Transport Oriented Development (TOD) 20-22 Atchison Street, St Leonards

State Significant Development Assessment Report (SSD-87486461)

June 2026

2 WEST BUILDING ELEVATION

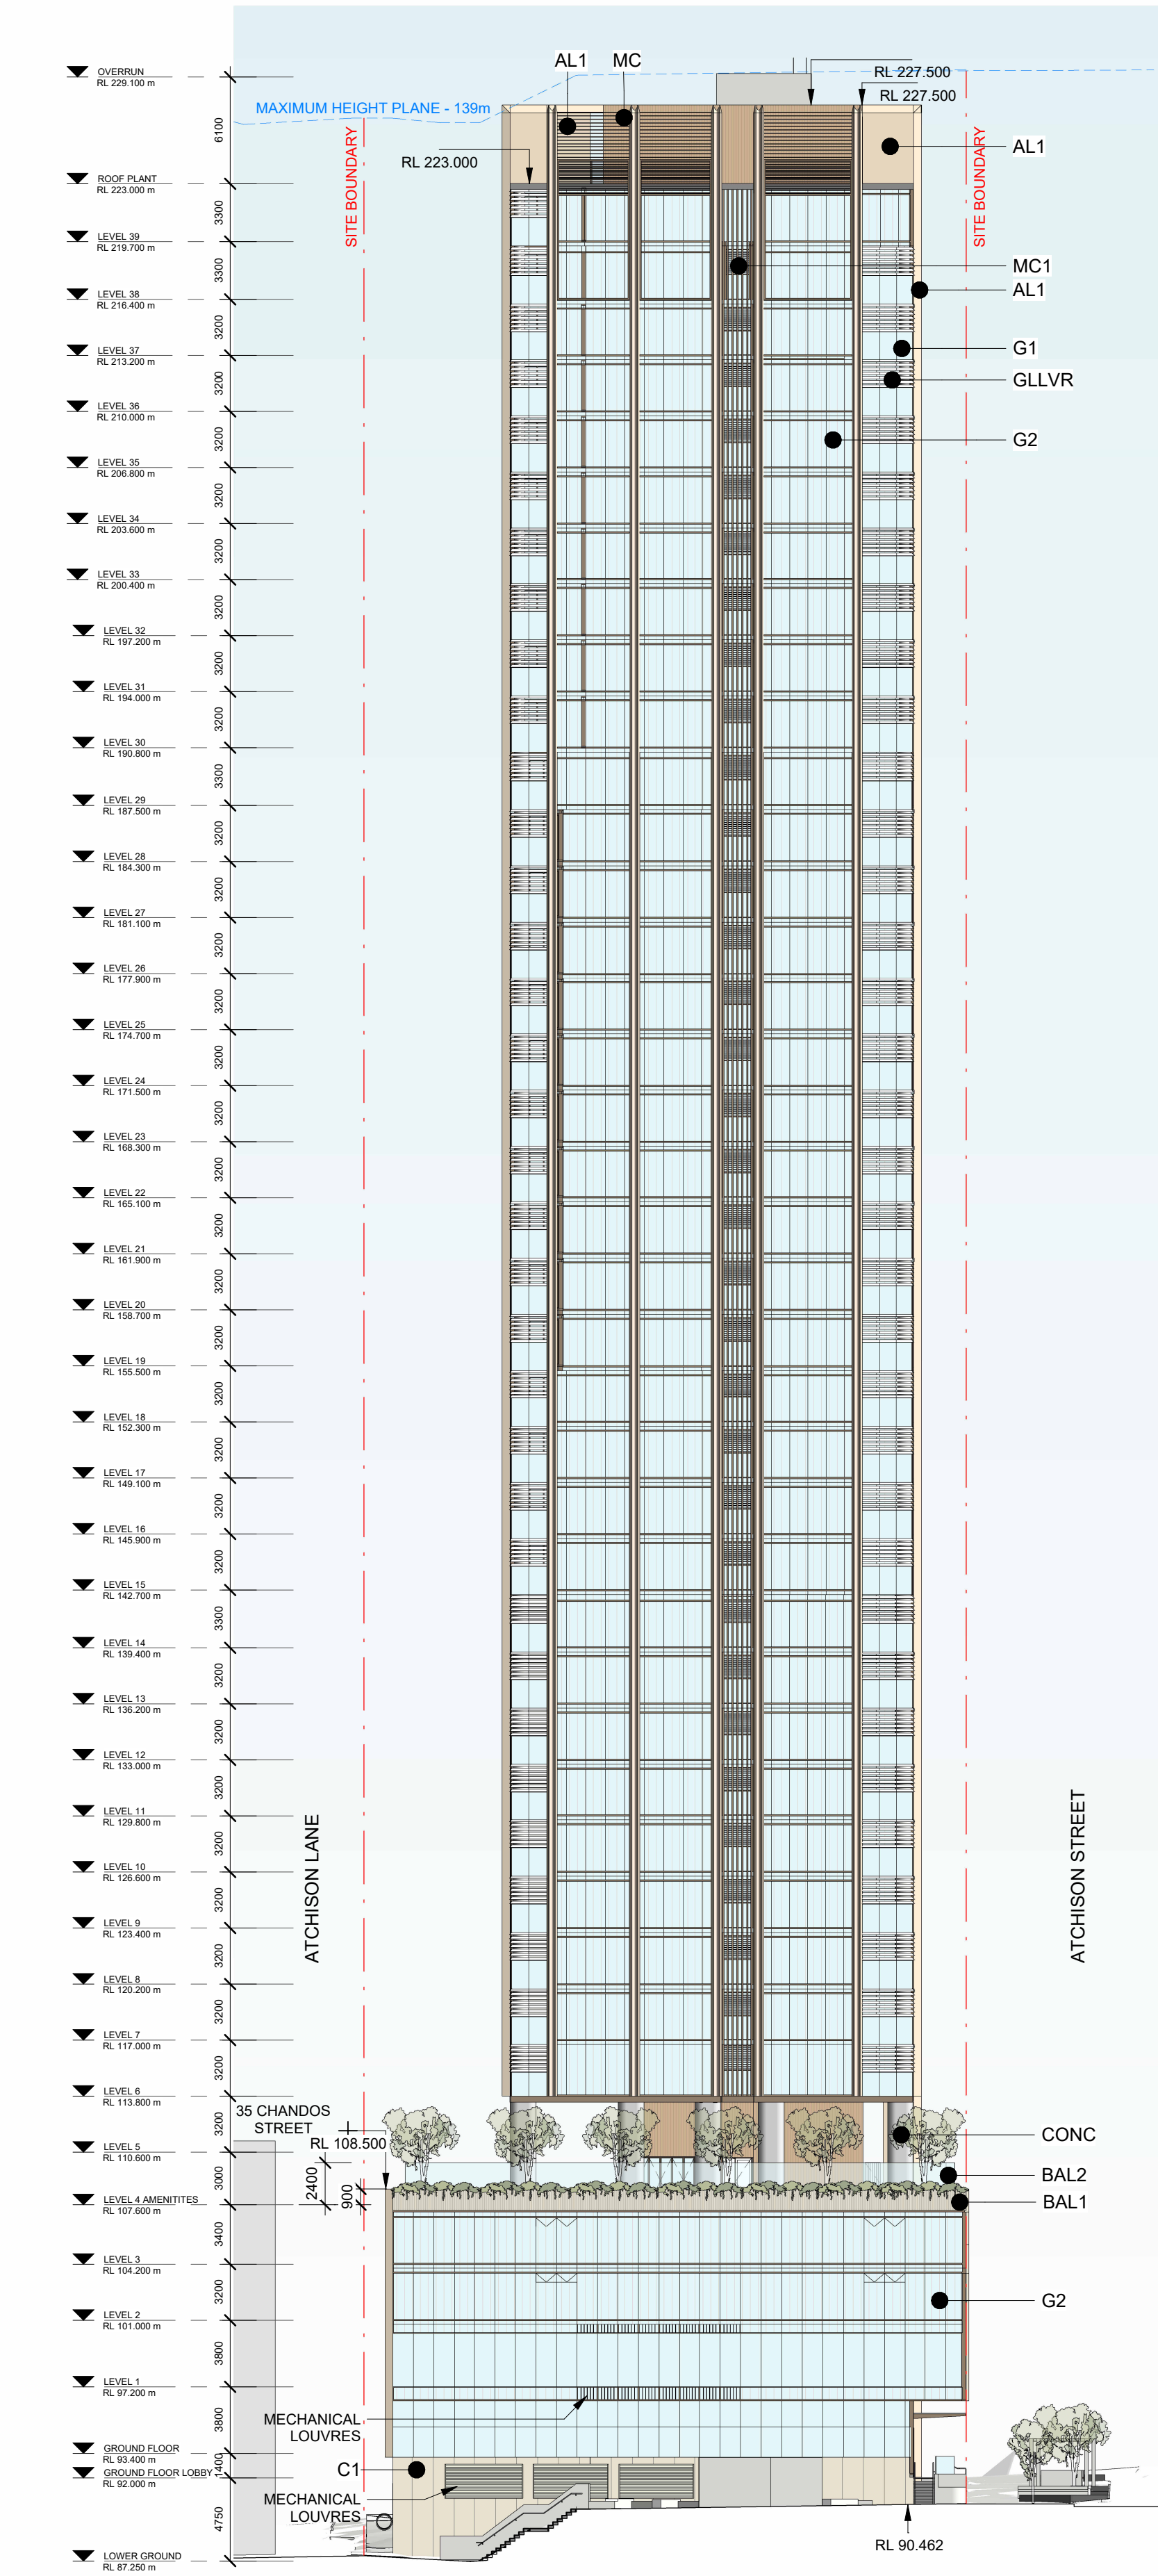
The proposed building separation to the adjoining property to the west at 6-16 Atchison Street does not meet the recommended ADG design criteria, providing a 0 m setback at the residential podium levels (Levels 2 and 3) and a 6 m tower setback. The proposed separation distance to the neighbouring building is shown in **Figure 5** below.

Council raised concerns that the non-compliant setbacks would result in an overbearing building with intrusive bulk and scale. The building separation distance and perceived bulk and scale of the proposal was also raised as a concern in the public submissions.

The Department has carefully considered the setback and building separation to the western boundary, as well as the Applicant's response and considers the proposal to be acceptable as:

- there are no windows on the western facade of the building, therefore preventing any direct lines of sight or overlooking opportunities and maintaining visual privacy of the neighbouring property which currently incorporates privacy screening on its eastern elevation

- the tower setback of 6 m is slightly greater than the 5.7m tower setback at 6-16 Atchison Street, responding to the existing built form of the neighbouring development and character of the surrounding area
